Environmental Impact Statement – The Northern Road Upgrade (SSI 7127)

WaterNSW has reviewed the EIS (Jacobs Australia for RMS; June 2017), and makes the following comments:

Figure 6.1
Sheet 1 of 4

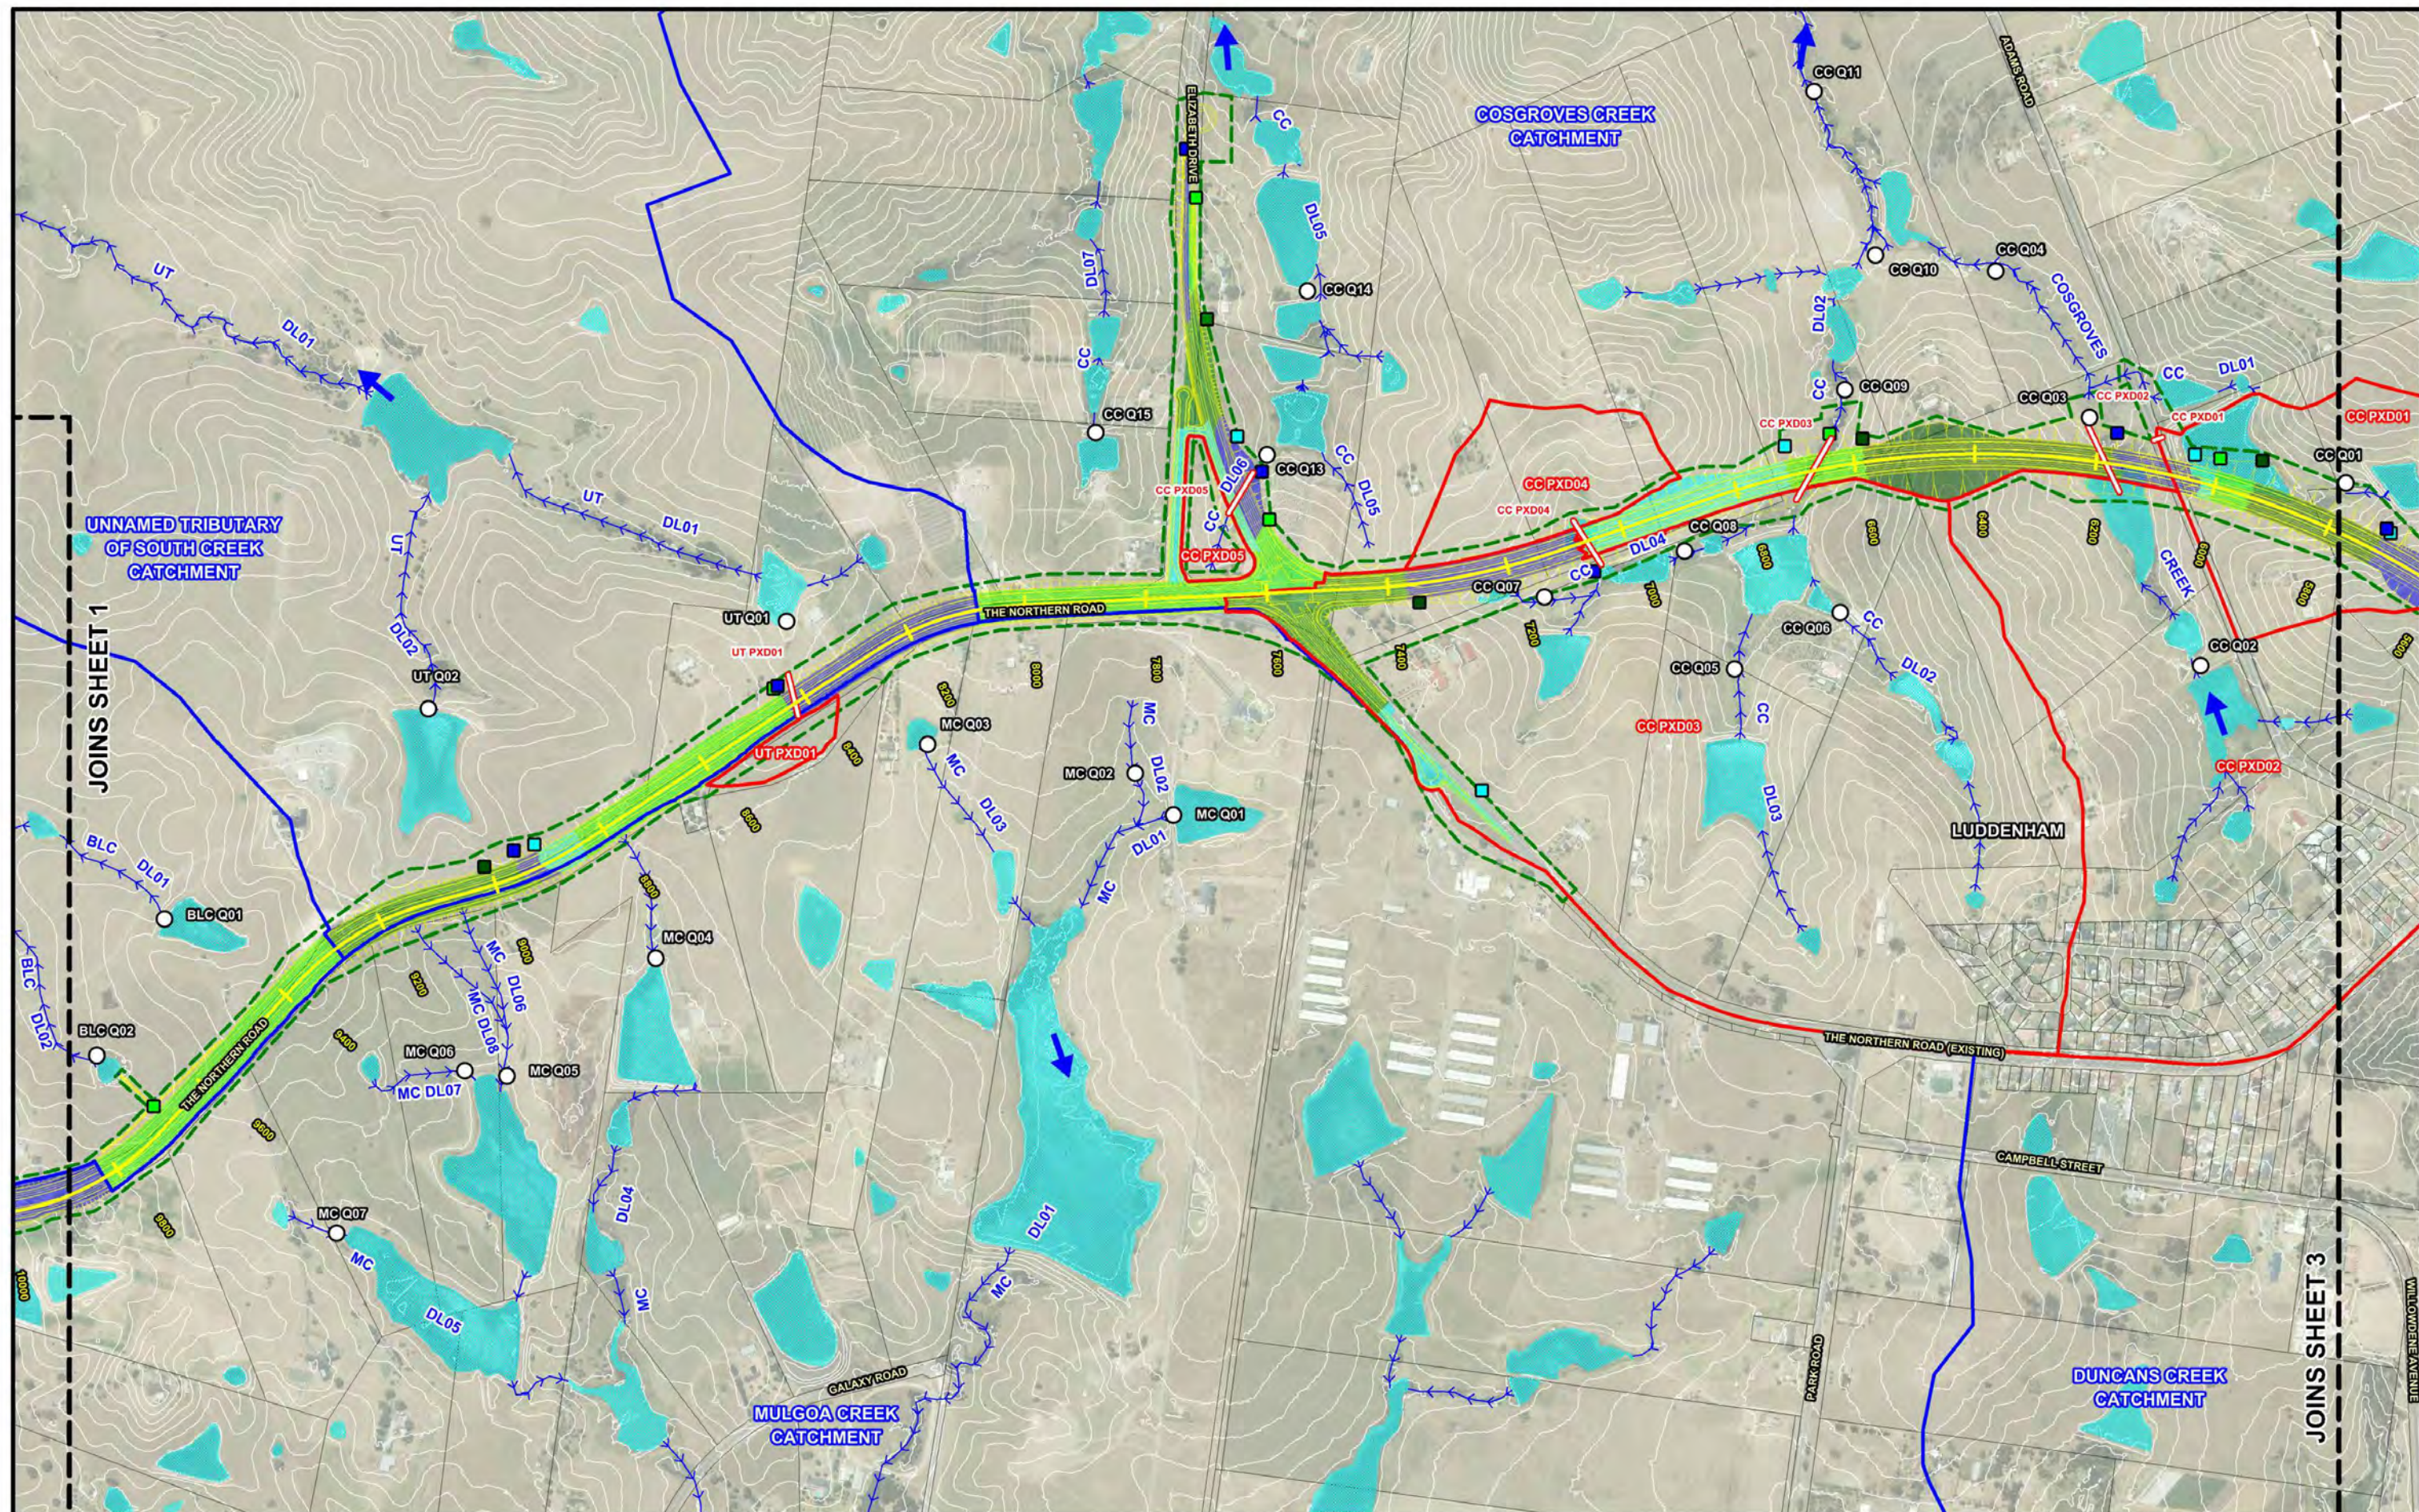
- into drainage line BLC DL03 from the works in the vicinity of Gates Road on Lot 23 DP 207317 (Appendix K; Figure 6.2; Sheet 2)
 - the diversion of flow from a section of the new six-lane road west along Littlefields Road where it would discharge to an existing dam located on the southern side of the road adjacent to the limit of works, which flows into the Pipeline corridor further west (Appendix K; Figure 6.1; Sheet 1).
